From: Ian Brewster [REDACTED]
Sent: 12 July 2011 13:36
To: James Smith
Subject: AW/145/11/T 261 Aldwick rooad, Aldwickj

## TPO for 261 ALDWICK ROAD, PO21 3QU

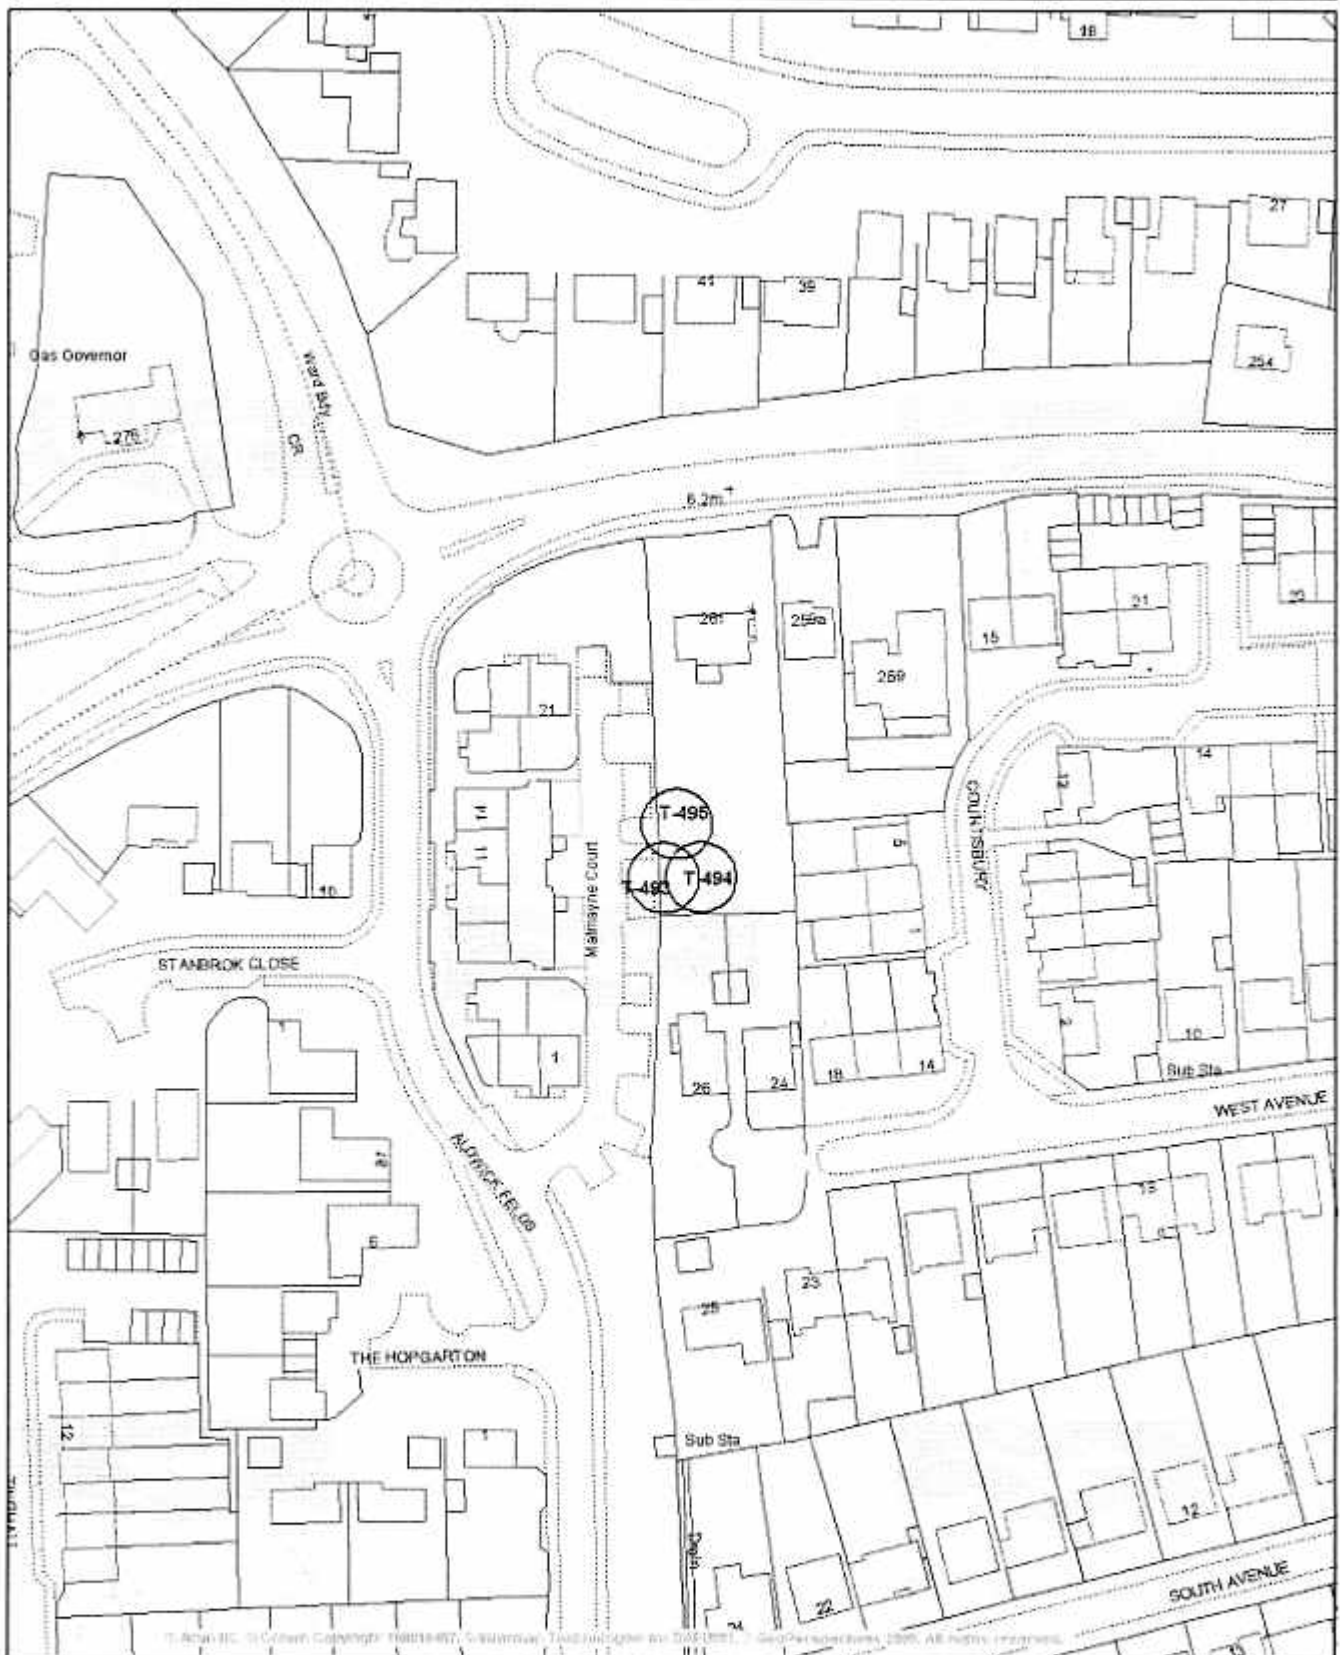
With regard to the above application, I accept the felling of the Horse Chestnut (now diseased and beyond recovery) and reduction of the 'leggy' Poplar tree. The English Oak is asymmetric having grown in close proximity to the Ash and Beech and would consider these as a 'Group' where the English Oak should be retained and not felled. The loss of the Horse Chestnut should be replaced with another suitable tree to be planted at an appropriate distance from the dominant Poplar tree.
